## **Suffolk County Council (20041323)**

Comments on any other submissions  
received at Deadline 4

## **Bramford to Twinstead (EN020002)**

Deadline 5

STOUR VALLEY WEST SEALING END COMPOUND: PLAN VIEW  
 SCALE 1:200

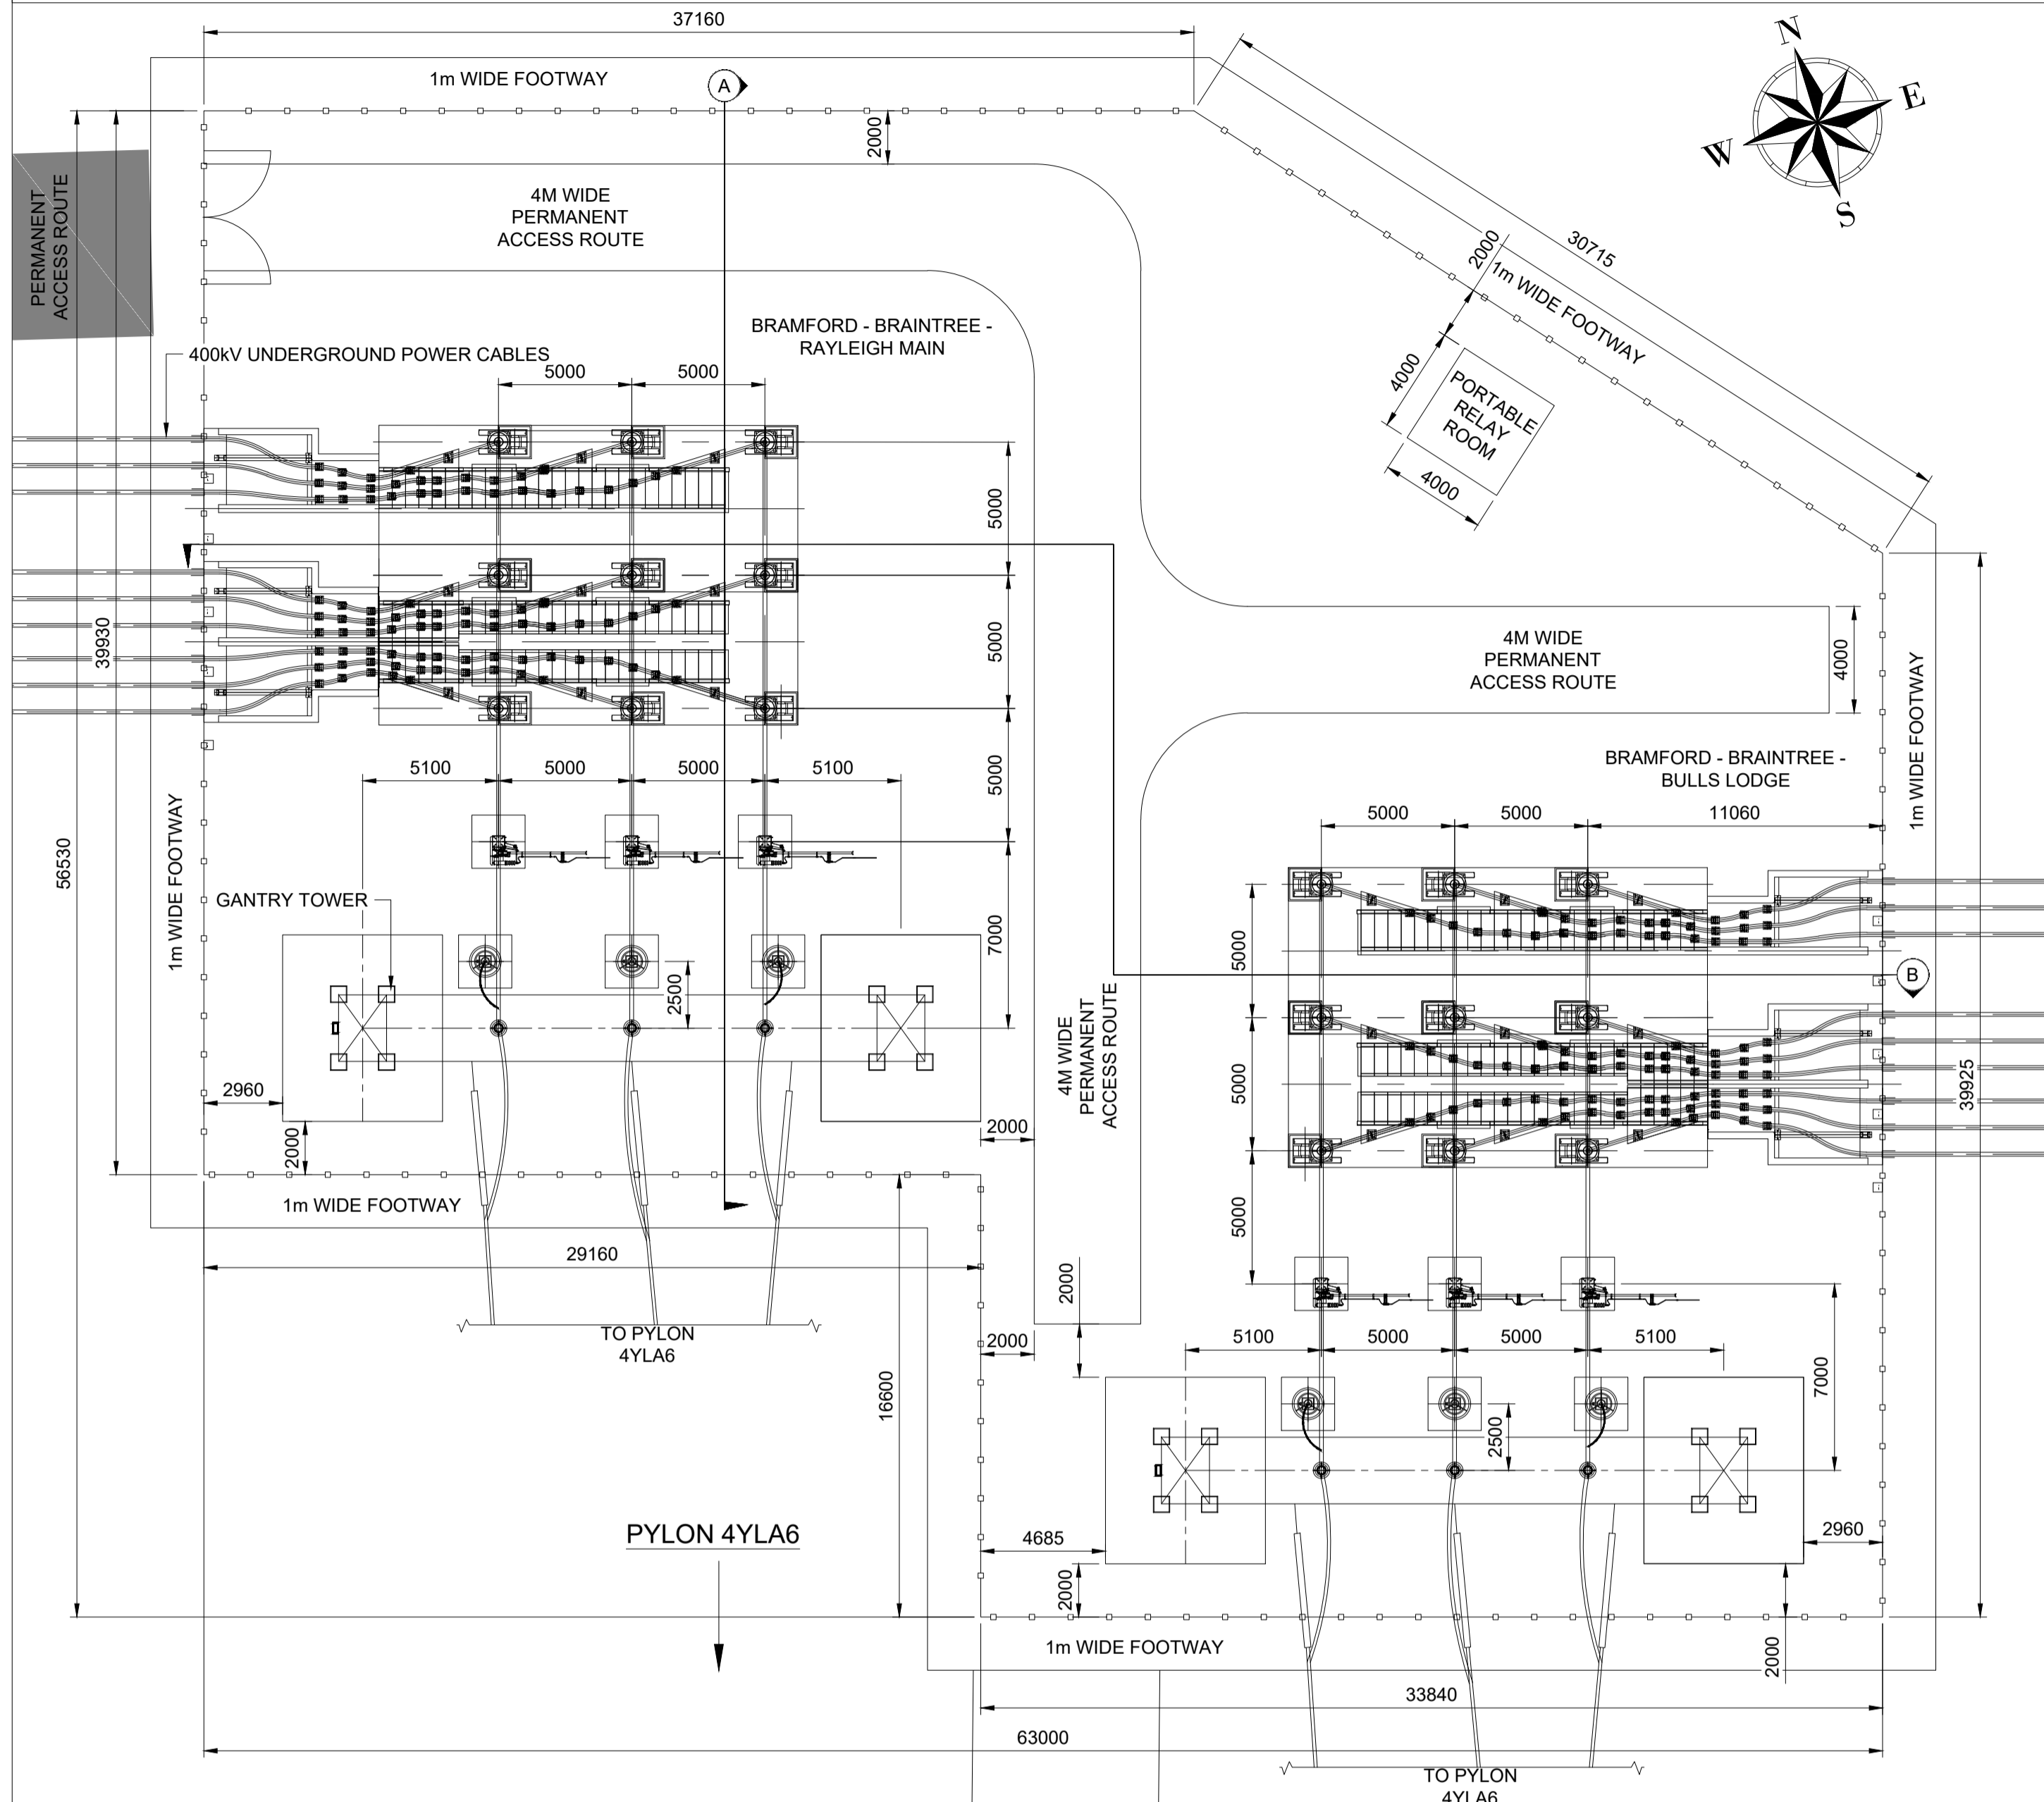
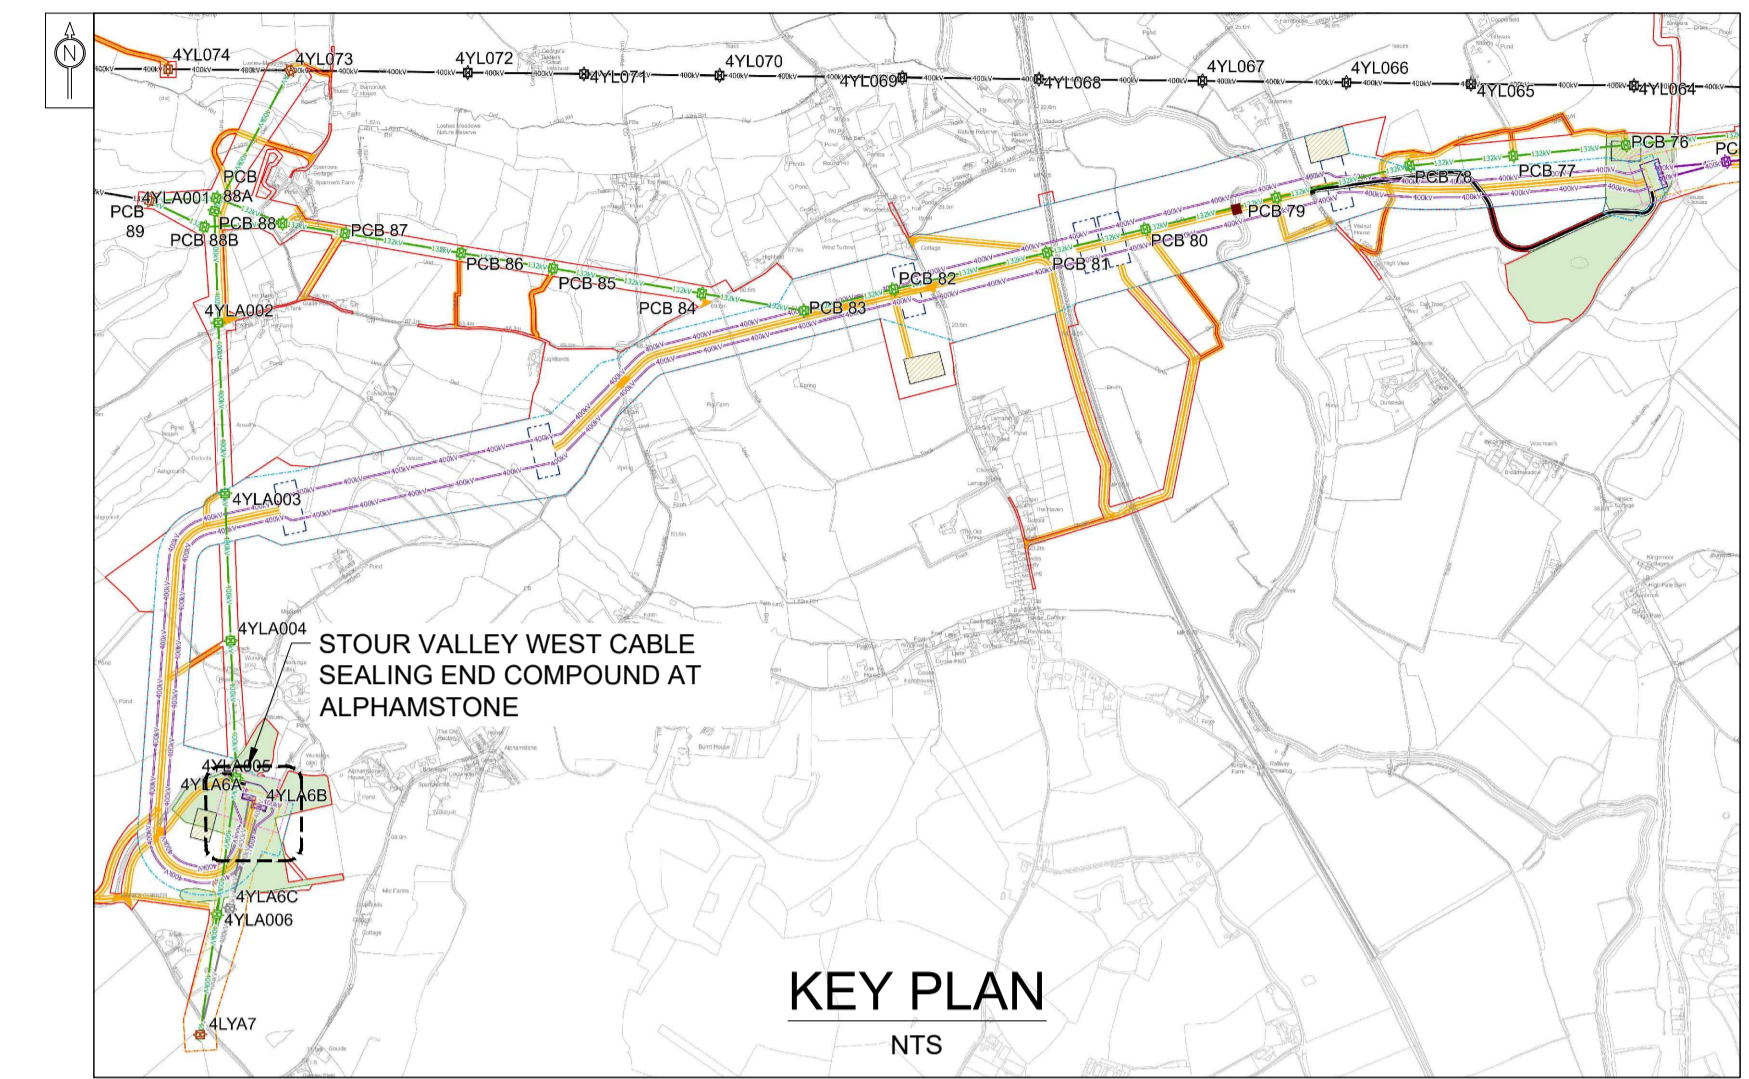
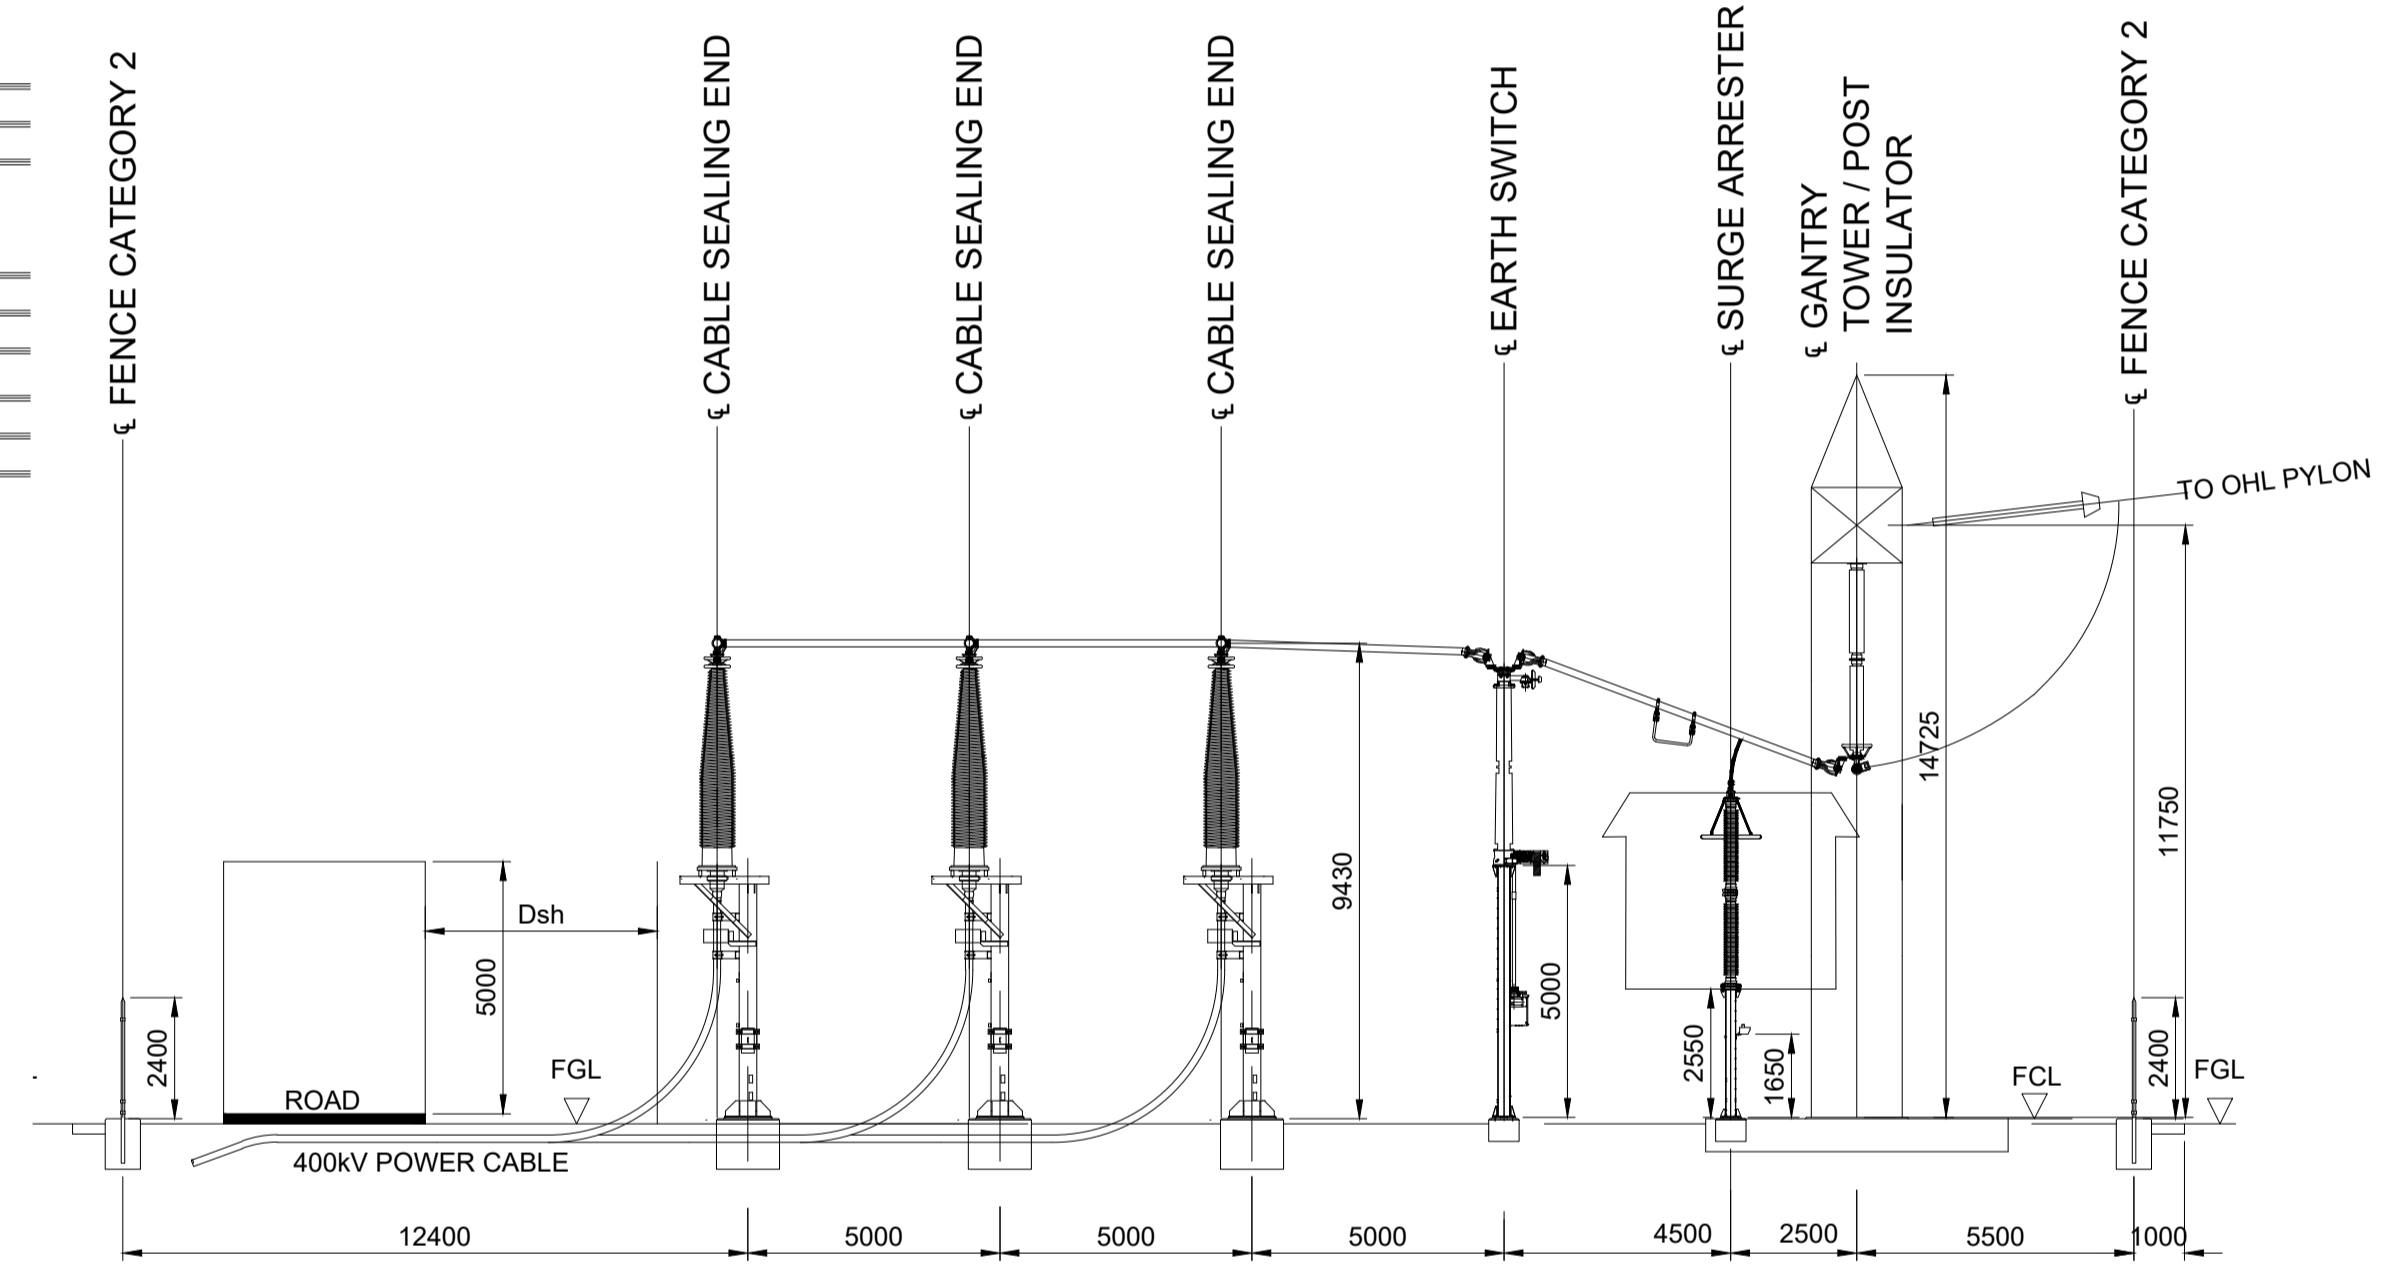
<b>Table 8: SCC Table of Comments on 8.6.3: Applicant’s Response to the November Hearings Action Points (CAH1, ISH2, ISH3, ISH4) [REP4-042]</b>			
<b>Ref</b>	<b>Topic</b>	<b>Reference Number and Comment</b>	<b>SCC’s Response</b>
8a	AP13		<p>From the Applicant’s response provided it is not clear where the permanent access route would cross Footpath W-171/001/0. SCC (Landscape) is concerned that a substantial part of the intervening vegetation that would potentially help to screen the view from across the Stour valley will be removed, not for the permanent access route, but for the works in general. This includes veteran tree T378, which according to the Applicant cannot be circumvented or drilled underneath.</p> <p>While SCC (Landscape) welcomes the commitment to ensure a landscape architect is involved in the detailed design of the permanent access route to advise on suitable finishes for the permanent access route at Stour Valley East CSE compound as part of reducing the landscape and visual effects of this feature, SCC expects that a suitably qualified landscape architect will be involved in the detailed landscape design throughout the entire project area.</p> <p>The embedded planting measures around the CSE compounds are not detailed enough to provide comfort that appropriate visual screening will be achieved.</p> <p>At the Stour Valley West CSE compound the proposed area for potential embedded planting seems insufficient.</p>
